CITY OF ALBUQUERQUE

November 1, 2022

Re: MAS Charter School
Neighborhood Impact Assessment, HT#L16D037
Report dated October 2022
Engineer's Stamp -----

The subject Neighborhood Impact Assessment (NIA) received October 20, 2022, has been reviewed by the City of Albuquerque Planning Development Transportation Section. The City request that the NIA be resubmitted with an Engineer seal for final approval.

Figure 14: Ross Avenue Loop and Church Lot Traffic Distribution

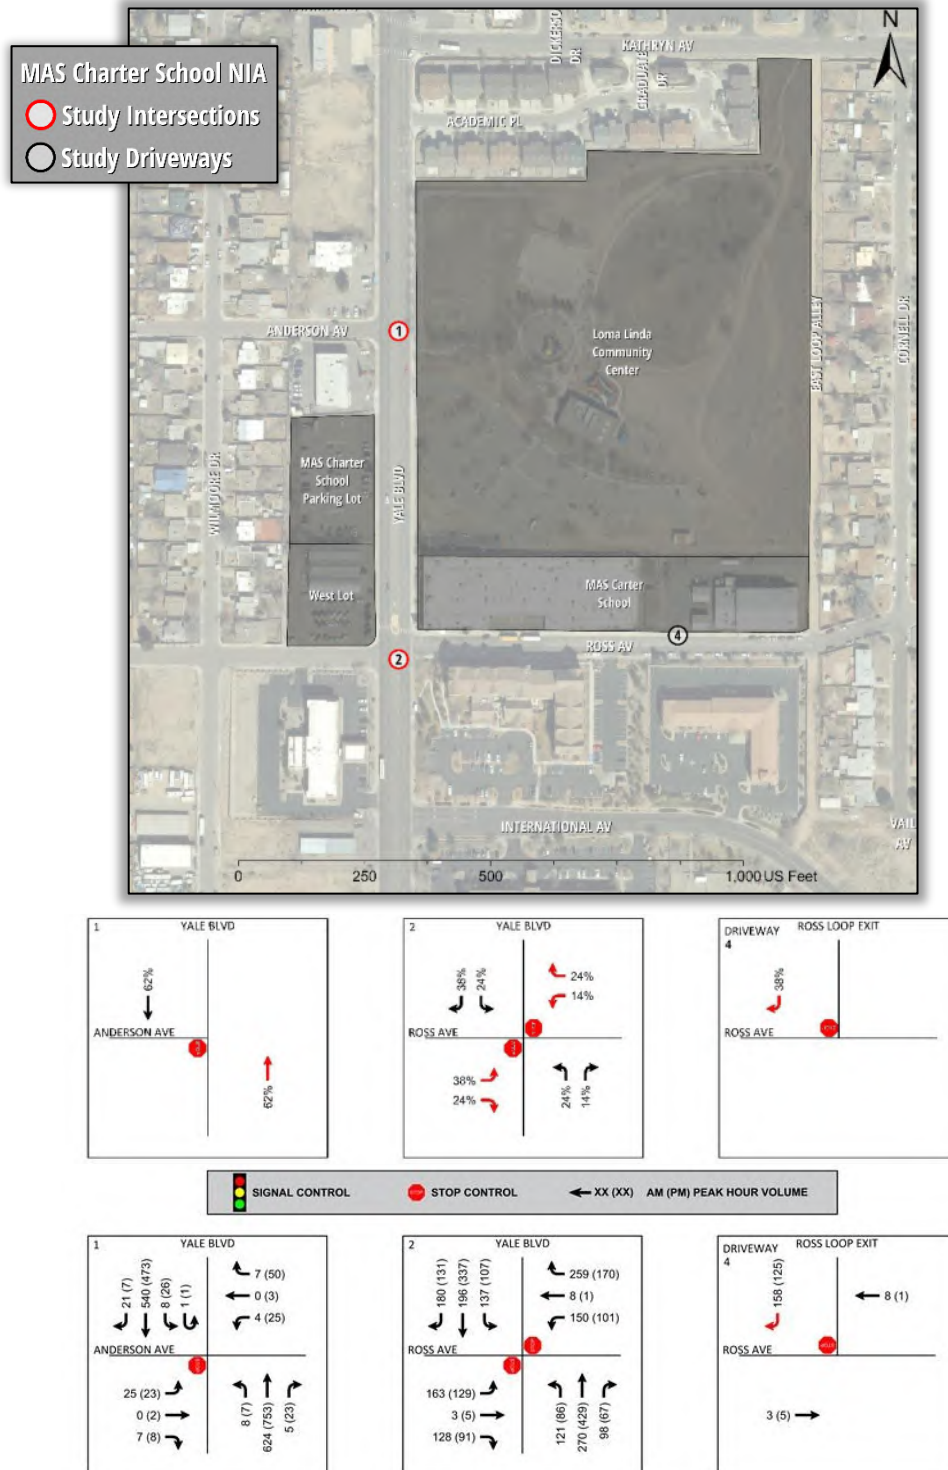
- Restricting traffic flow resulting from traffic queuing on Ross Avenue east of the school is prohibited. Do Not Block Intersection pavement markings shall be applied, communicated to parents, and firmly enforced.
- An exclusive right-turn lane should be striped on northbound Yale Boulevard between Ross and International Avenues to add queuing capacity to the intermediate drop-off/ pick-up (Ross Loop) scheme and per CABQ DPM.

Figure 17: West and Community Center Loops Traffic Distribution

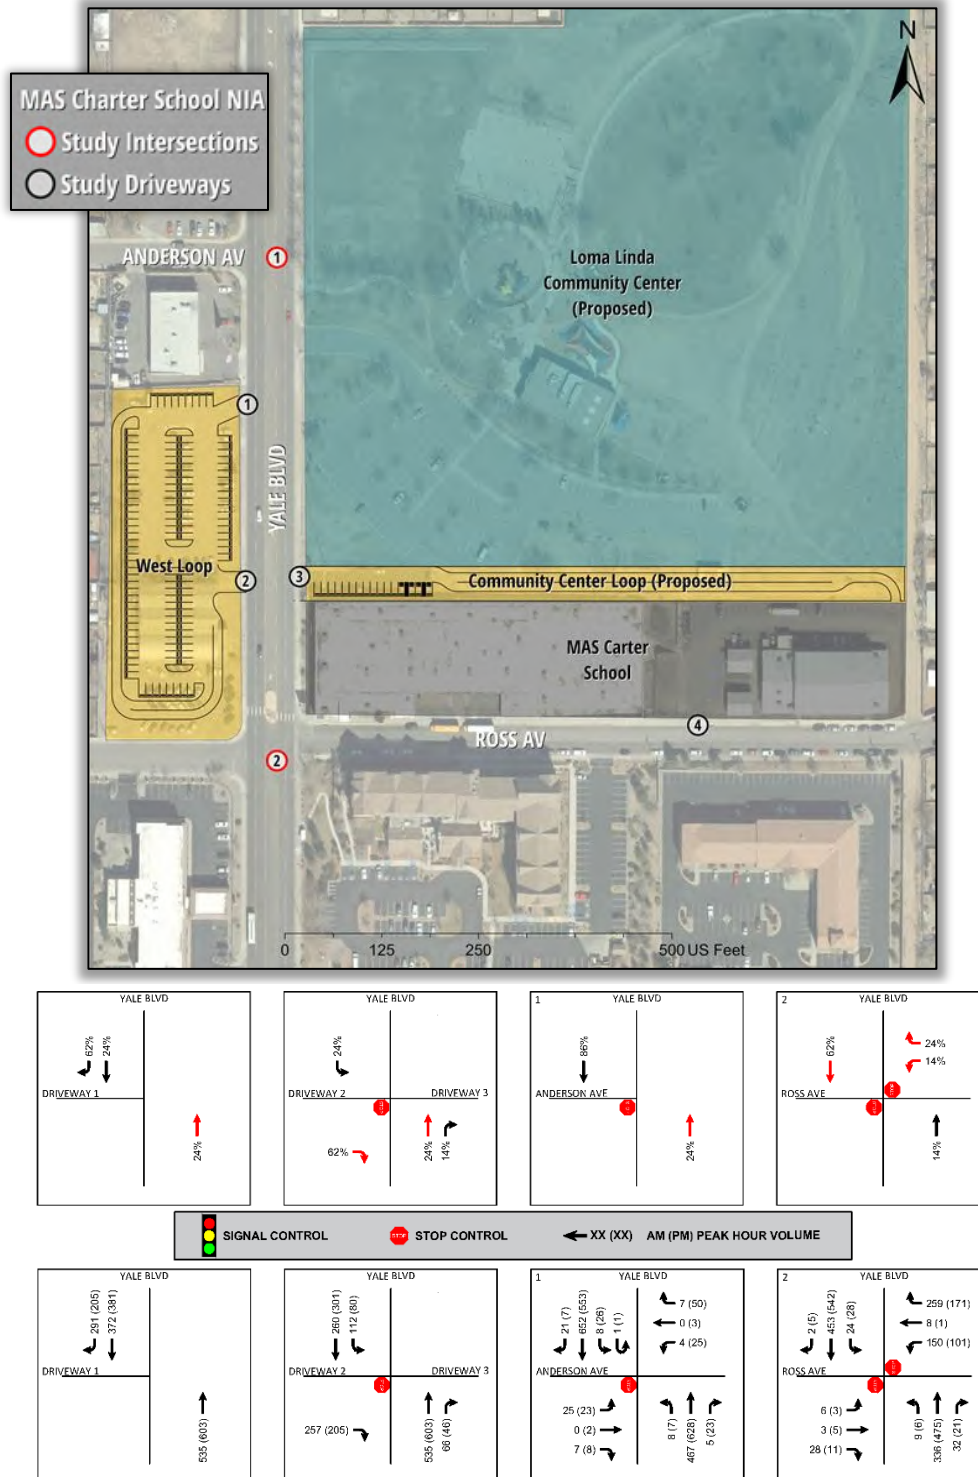
- For the Community Center Loop establish a median treatment to restrict left-turns from northbound traffic to access Driveway 2 while allowing southbound traffic to complete left-turns to access Driveway 3.
- For the Community Center Loop, auxiliary right-turn lanes are established on Yale Boulevard for Driveways 1 and 3.

Figure 19: West and Ross Avenue Loops Traffic Distribution

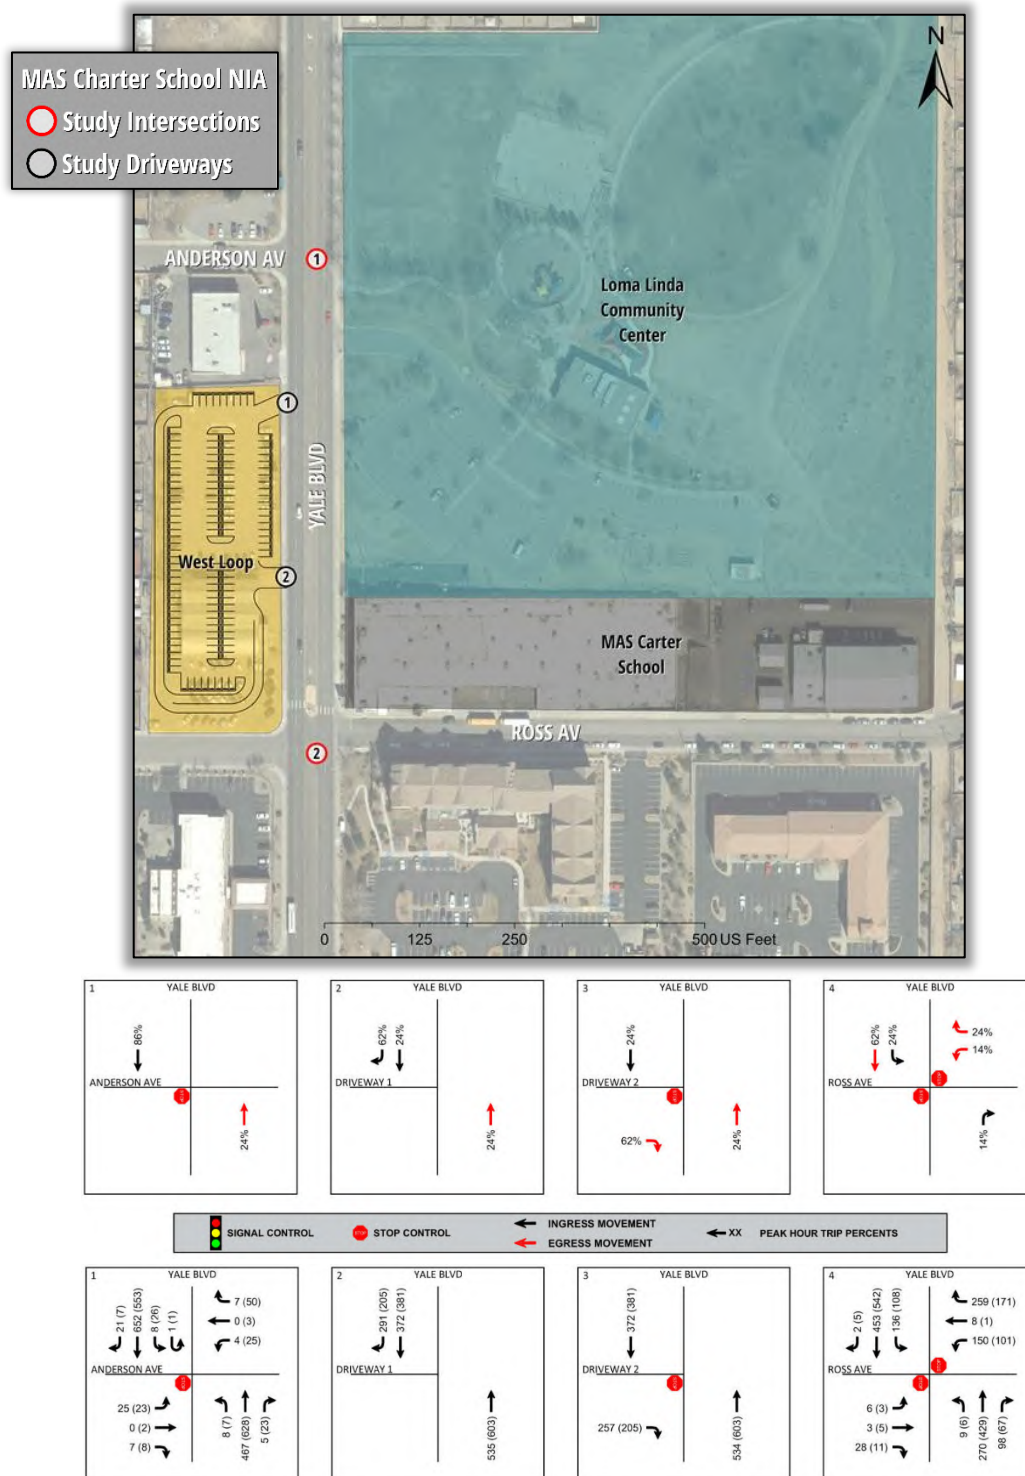
- Blocking the business's driveway, north of Driveway 1, is prohibited. Do Not Block Intersection pavement markings shall be applied, communicated to parents, and firmly enforced.
- An exclusive right-turn lane should be striped on northbound Yale Boulevard between Ross and International Avenues per the CABQ DPM for the West Loop alternatives.
- Access to the site is maintained via the drop-off/pick-up operations map provided in the report.
 - Driveway 1 - right-in only
 - Driveway 2 – right-out only
 - Driveway 4 – right-out only
- Stripe a through/right turn lane on Yale Boulevard for Driveway 2 egress.

- Install plastic bollards between the turn and through lanes at Driveways 1 and 2 to communicate the right-in, right-out access of these driveways.
